From: Carol Reynolds
Sent: 11 August 2019 21:53
To: Planning.Responses <Planning.Responses@arun.gov.uk>
Cc: Anita Gardner <Anita.Gardner@arun.gov.uk>
Subject: FW: Application Ref: LU/164/19/PL - 5 Arundel Road, Littlehampton

Environmental Health: Noise

Environmental Health: I acknowledge information already provided in the Planning Statement, dated May 2019, Ref 13538. I now refer to that Noise Assessment, Job Number A113884, 3rd Issue, prepared by Wyg.

Studio Lack Architecture Studio Lack Ltd : 17 Beech Avenue : Chichester 01243 782 686 : nicholas.lack@live.com : PO19 3DR	5 Arundel Road, Littlehampton	Block/Site Plan 28/03/19 1/500 @ A4	Dwg 1915-03C
--	---	---	-------------------------

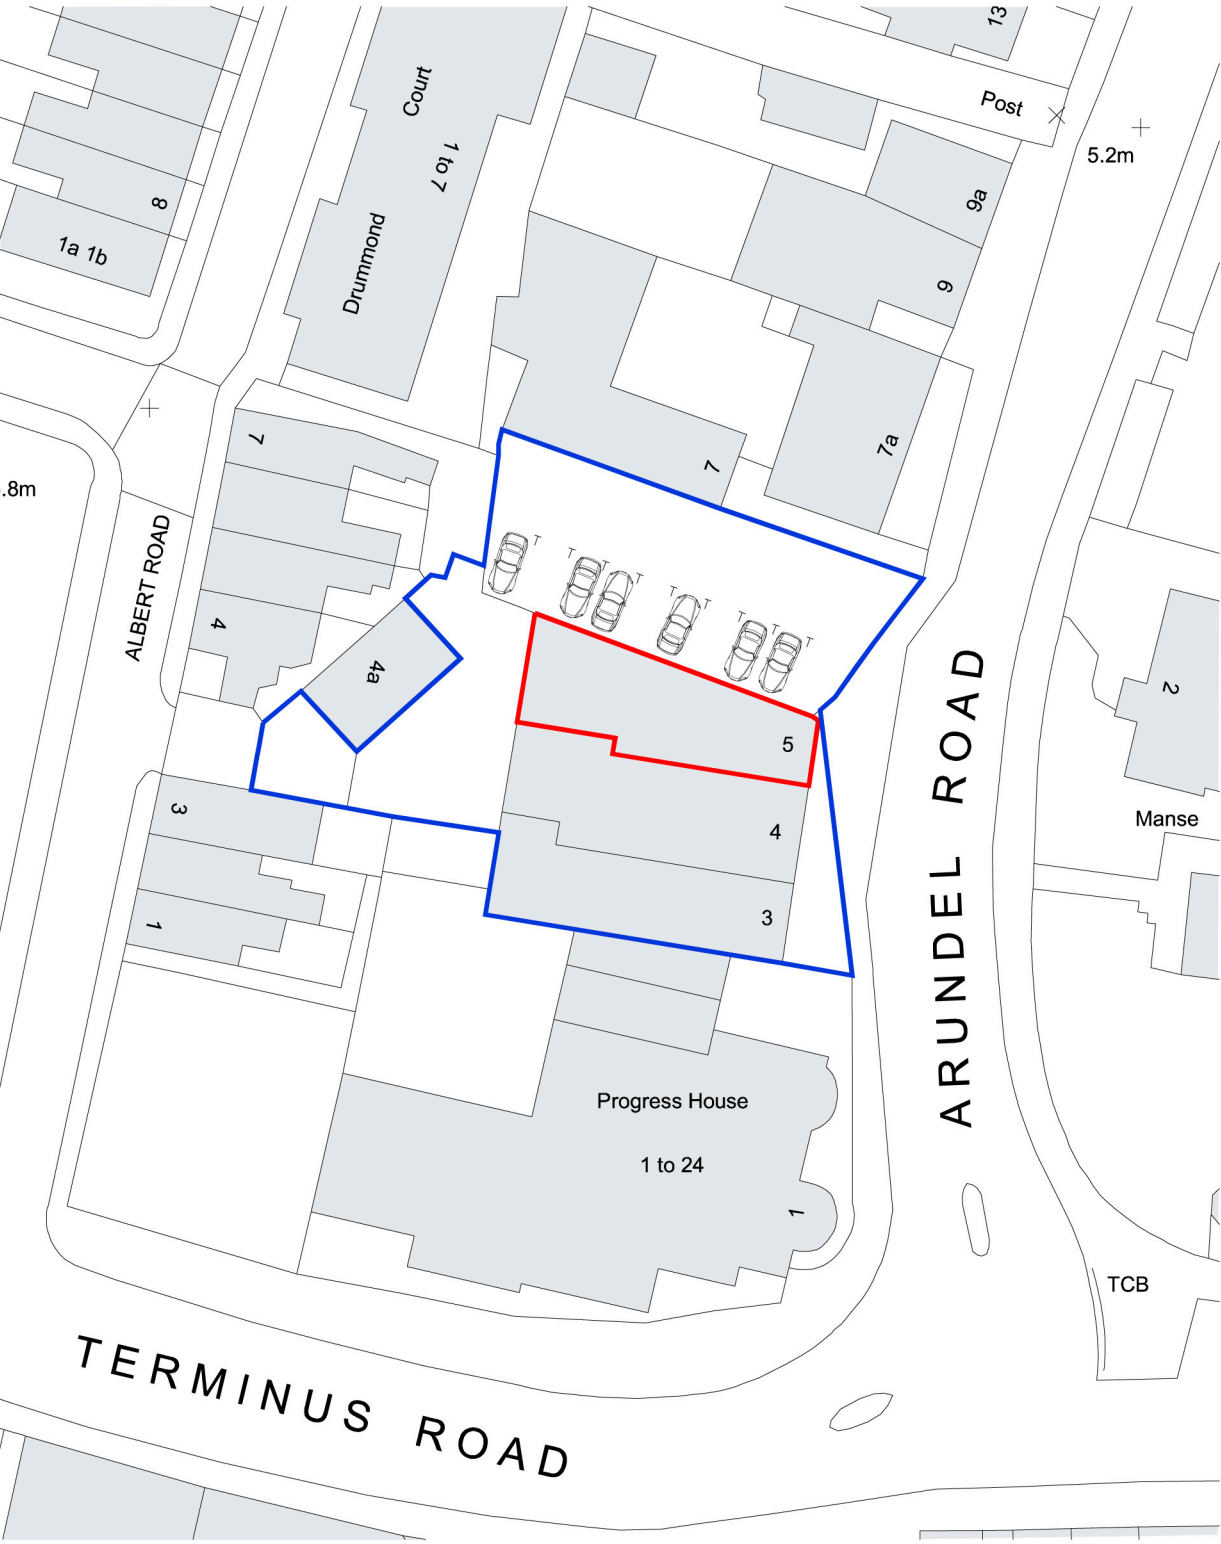
In respect of car parking, the acoustic report needs to be expanded to properly describe the acknowledged intensification of use of this space, ie the number of customer as well as the number of delivery vehicles and the type of delivery vehicles such as mopeds, etc which will arrive at/depart from this site over a given time during proposed operating hours and how this will affect the acoustic environment, particularly of sensitive receptors R5 to R10 and mitigation measures that may be necessary.

This includes an assessment of noise arising from the roof mounted air intake and extract flue, the extract ventilation to the kitchen sinks, the number of customers collected orders from the site, and the different vehicle types used for delivering orders to customers.

Studio Lack Architecture Studio Lack Ltd : 17 Beech Avenue : Chichester 01243 782 686 : nicholas.lack@live.com : PO19 3DR	5 Arundel Road, Littlehampton	Proposed Elevations 30/03/19 1/100 @ A3	Dwg 1915-07B
--	--	---	---------------------

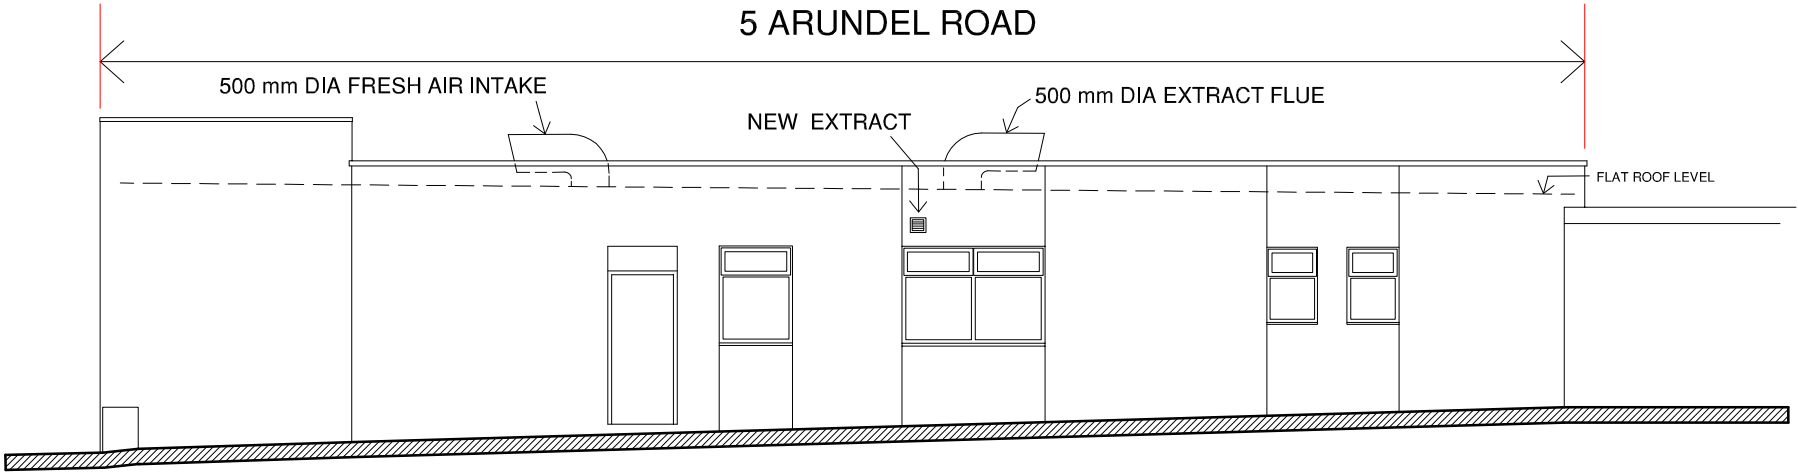
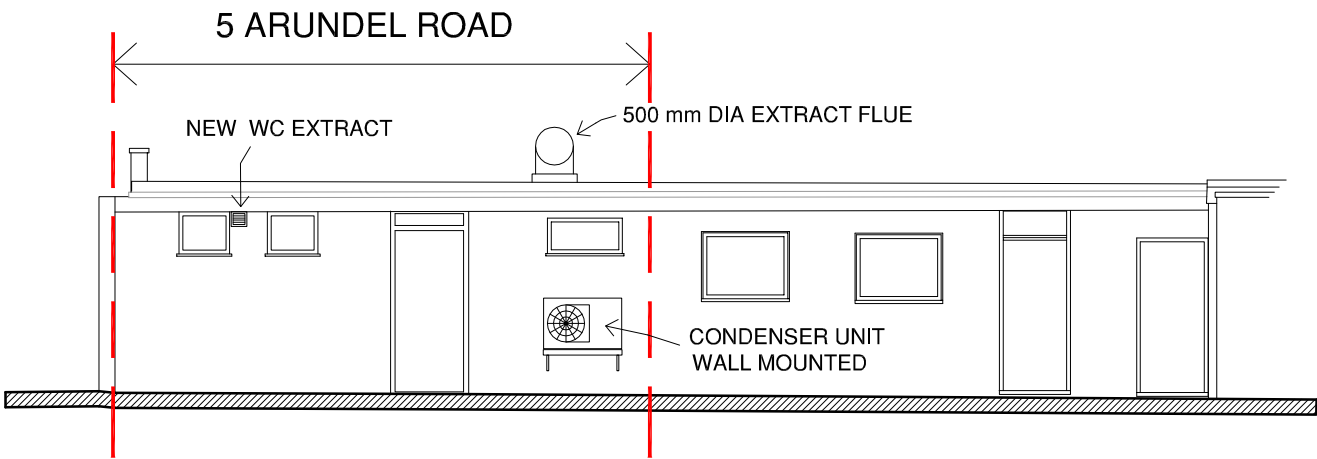
Unfortunately this report only considers noise from the condenser unit to the walk in chiller, whilst excluding other new noise sources particularly in respect of noise from the air intake and exit flue to the flat roof of this single storey building above the kitchen odour abatement system, but also extract ventilation to the kitchen

sinks. Please would you request that the applicant also provides proper assessment of these areas, together with detail of any further mitigation measures that may be necessary

The overall conclusion of the assessment remains, as per the original assessment, that the proposals would not give rise to unacceptable noise impacts on nearby receptors.

Dwg 1915-08B

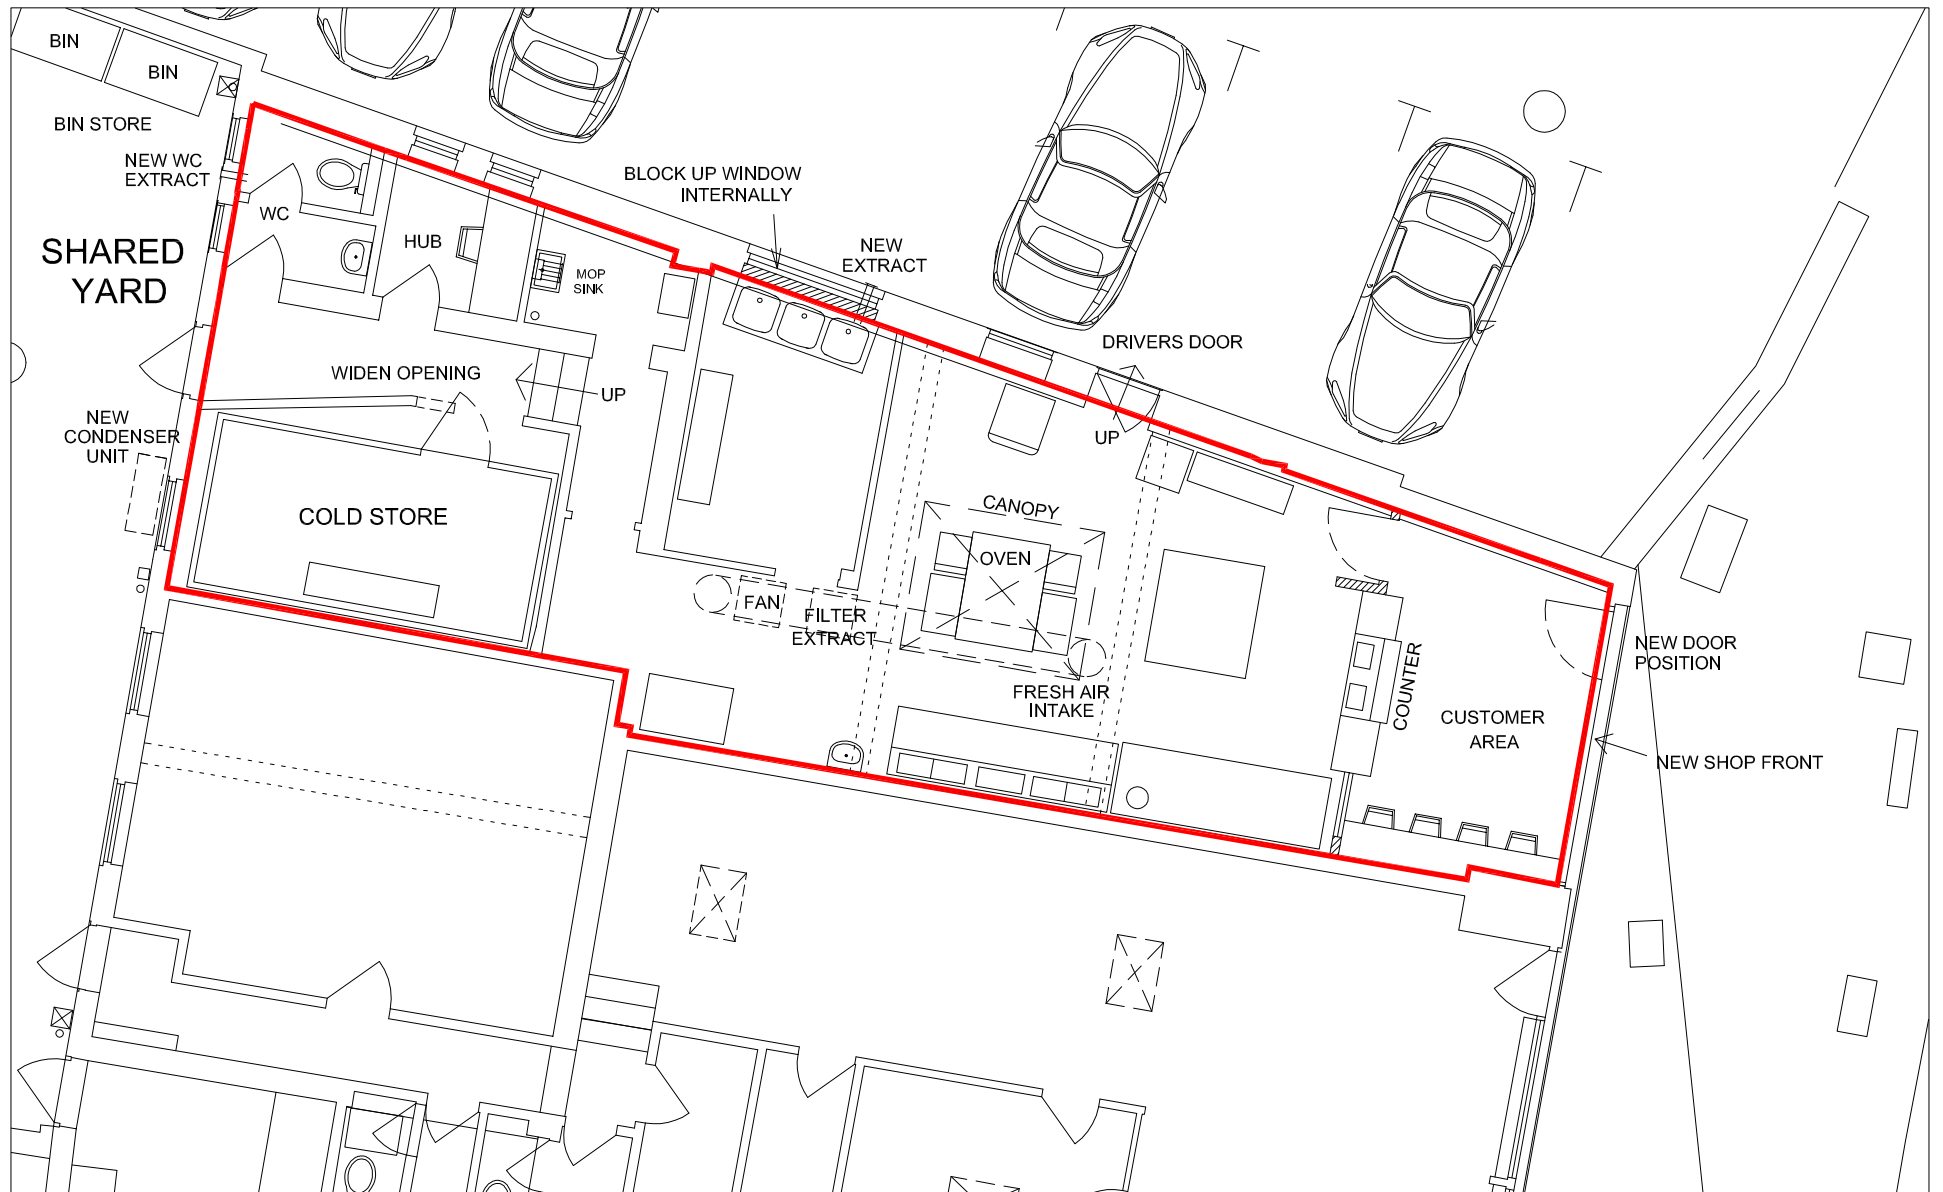
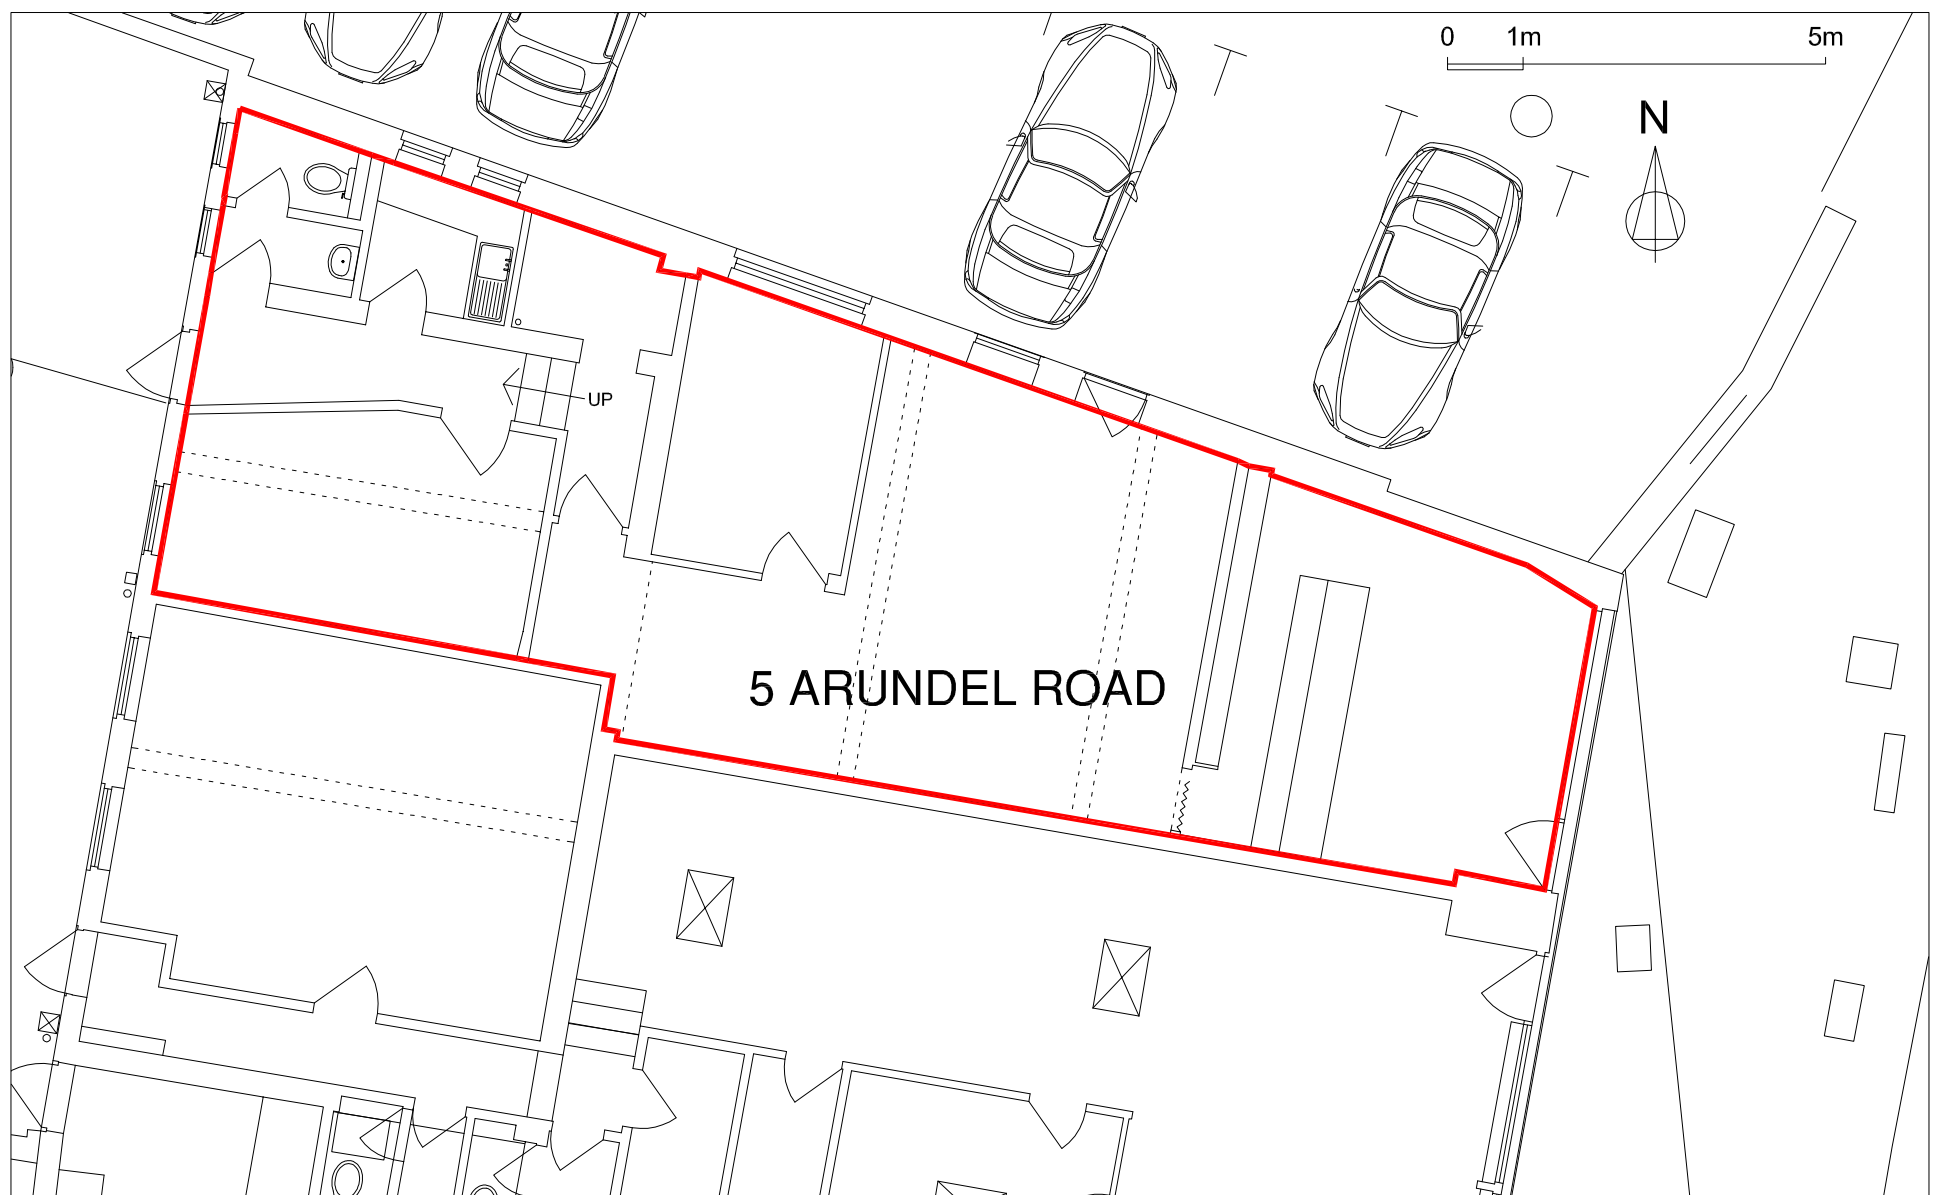
Informative: I await the applicant's response to my previous comment re kitchen layout and Wyg Odour Assessment, June 2019.

Odour Assessment: See Wyg Job Reference Number A113884, 4th Issue, 18th June 2019 and Defra Guidance on the Control of Odour and Noise from Commercial Kitchen Exhaust Systems, 2018. The proposed flue will discharge to the roof of this single storey business where it is surrounded by higher levels domestic residences. For this reason then I would dispute a dispersion Score of '10 – Moderate' instead applying the Rating '20 – Very poor,' particularly since this faces sensitive rooms of that home to the immediate north of the development. I would also Rate the size of this kitchen as 'Medium – 5 rather than Small – 1' and the type of cooking as '4 – Medium.' I agree with the Rating of 10 for the proximity of receptors, which leads me to the overall Odour Risk Assessment of 37 and the need for a 'Very High' level of odour control. Alongside baffle filters detailed then specification to be given for the type of prefilter to be provided as well as clarification as to a 0.4 second retention time through the activated carbon filters.
